From: Samantha Lee [REDACTED]
Sent: 21 August 2019 11:46
To: Richard Castro-Parker
Cc: Daniel Vick
Subject: RE: BE/139/18/PL - Innovation Centre Beeding Close
Attachments: UNDA 100 Scale Layout.pdf; UNDA 400 Scale Layout.pdf; Souther Warter Sewer Records.pdf

Further to our telephone calls today, I had already asked the Laura Gibbons about the drainage matters you raised (see my email below). Laura has commented and has requested the following:

- Proposed Drainage Layout – 1:100 Scale;
- Proposed Drainage Layout – 1:400 Scale.

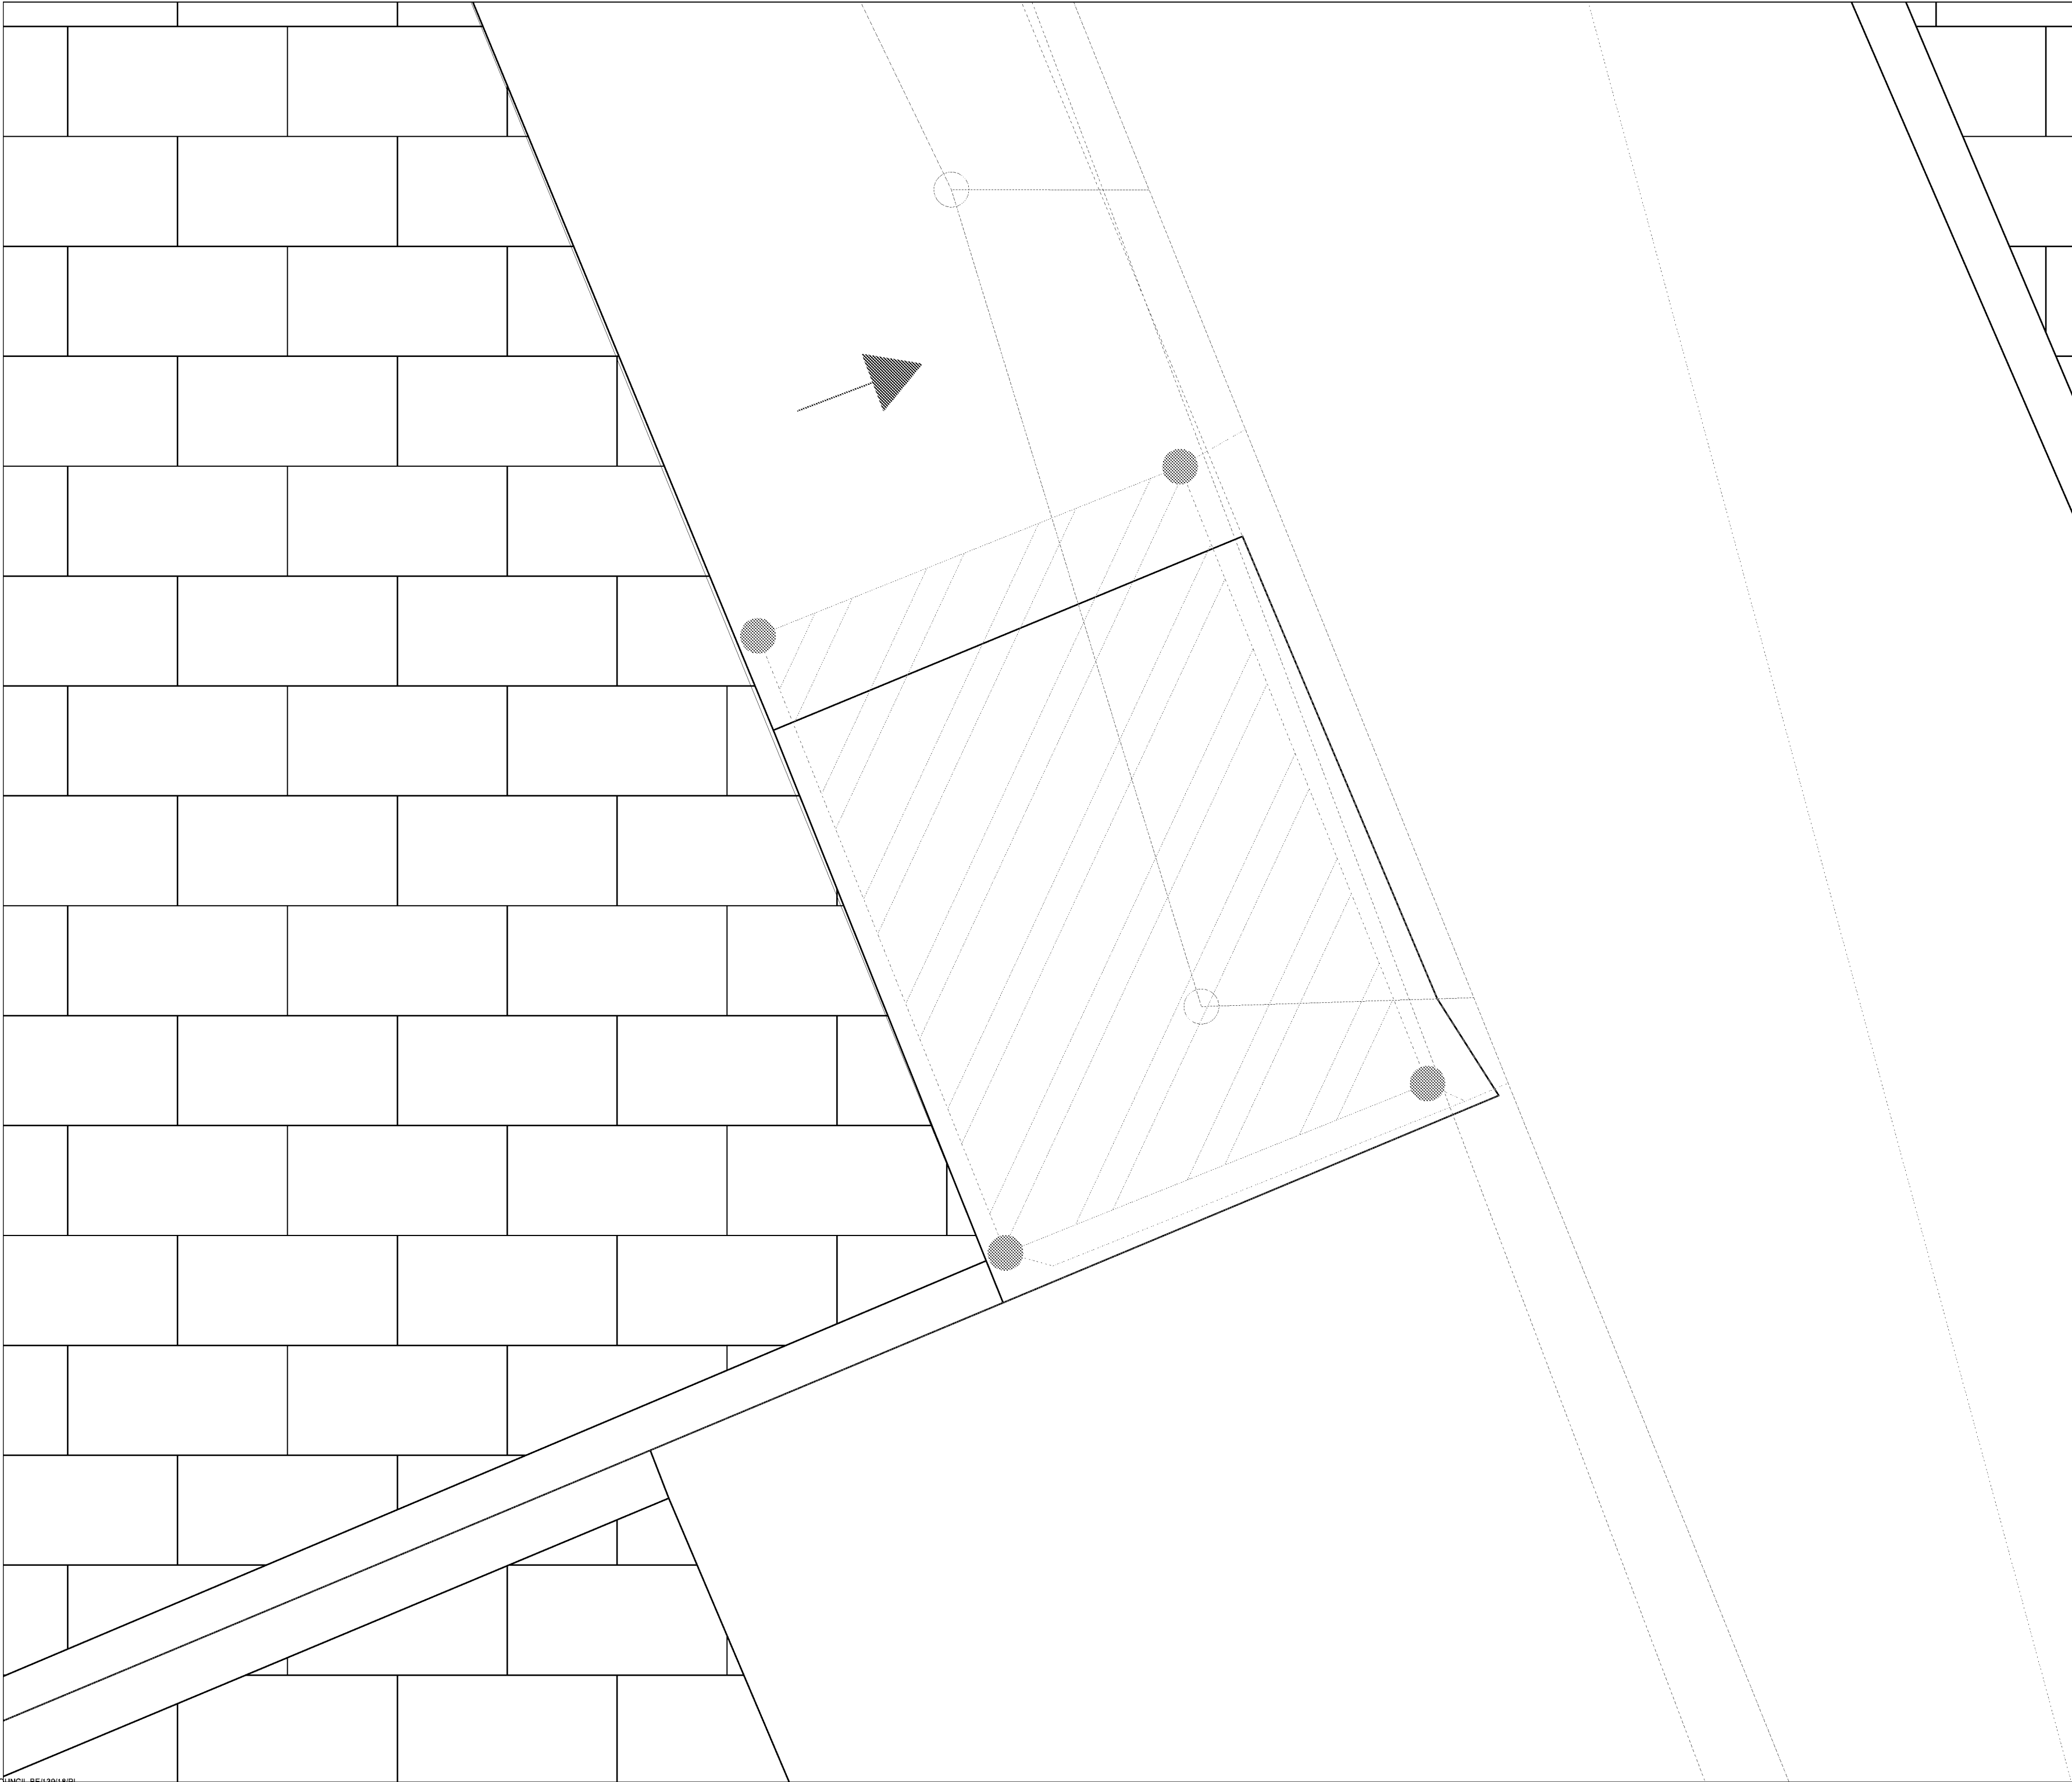
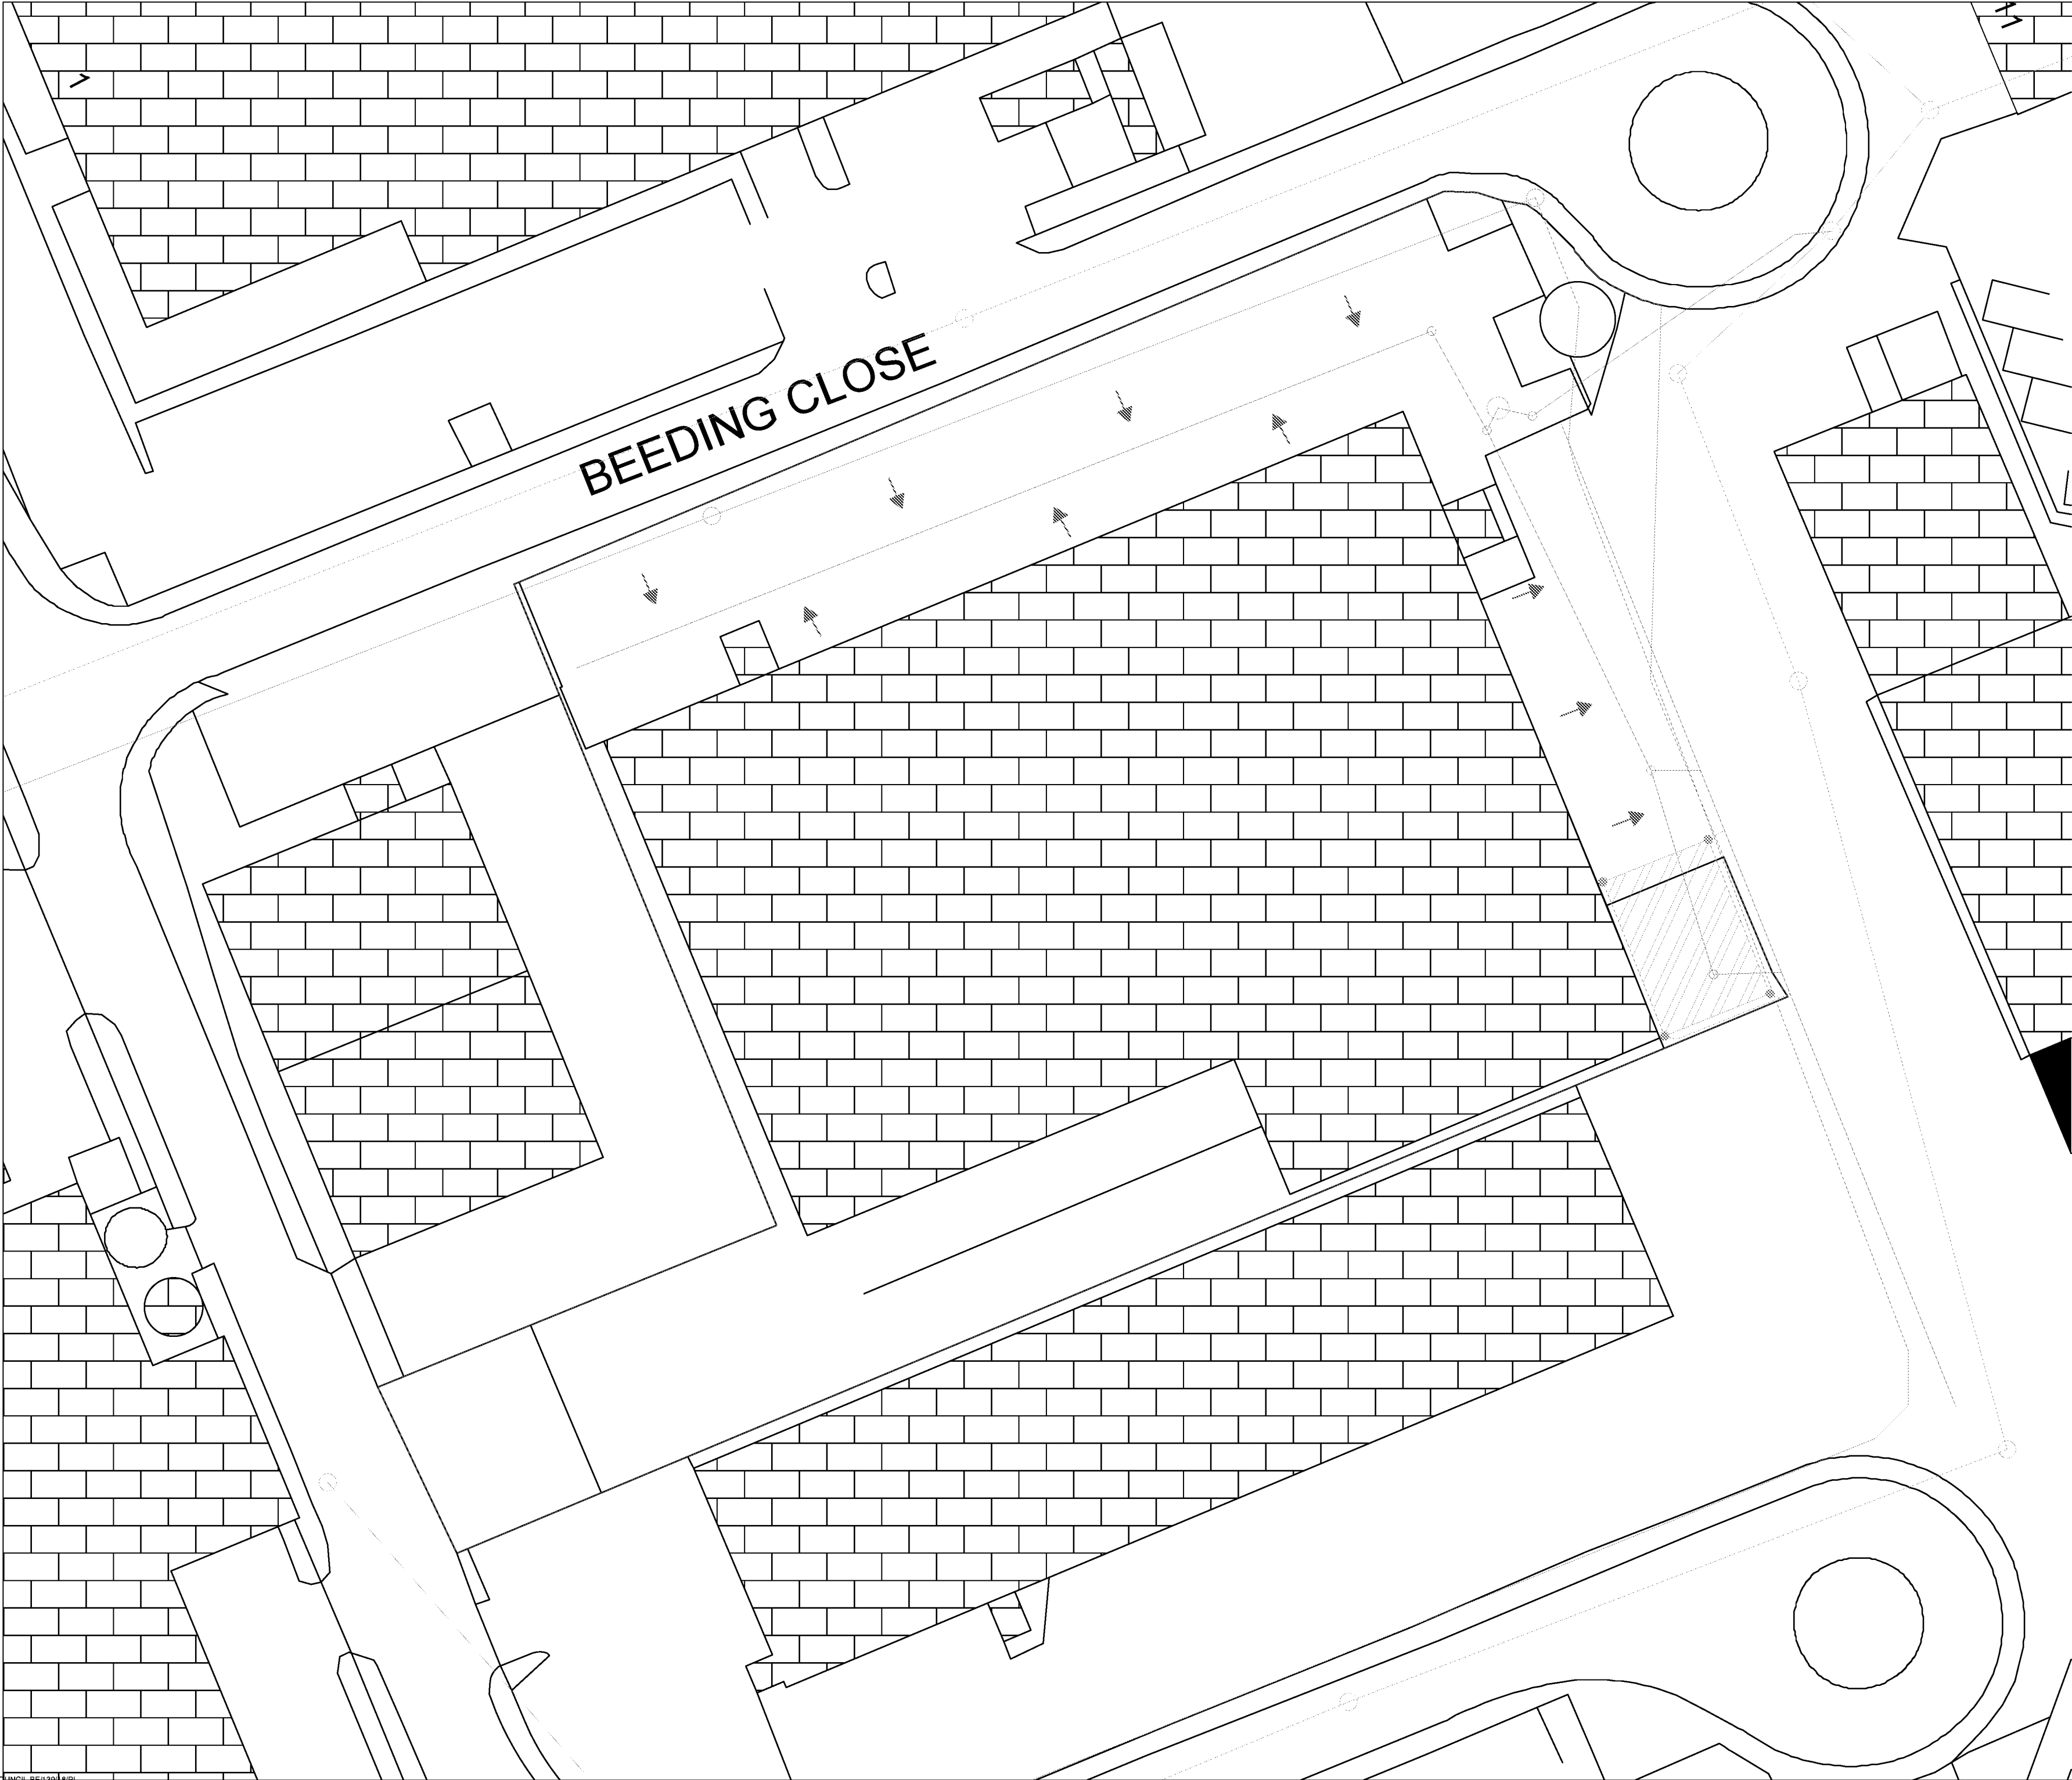
Please can the applicant submit clearer plans of the proposed surface water drainage arrangement. I.e. different line types used, rather than all very similar colours. Please can gullies, manholes, and linear drainage channels be clearly labelled.

I also require levels to be submitted showing invert and cover levels of the existing drainage network and spot levels of the surrounding land. This is fundamental to ensure that the surface water from the development does not go off site.

Please find attached a PDF of the drainage layout plan for the site. Given the size of the site, all lines on the plans are small. However, if Laura zooms in she will be able to distinguish between the pipes types. This should hopefully address her first concern.

With regards to levels, having reviewed the sewer asset location search requested from Southern Water, both invert and cover levels for all Southern Water manholes are detailed within their response. A copy of the sewer asset location search was included within the appendix of the Surface Water Drainage Strategy -- this have been attached to this email for her reference.
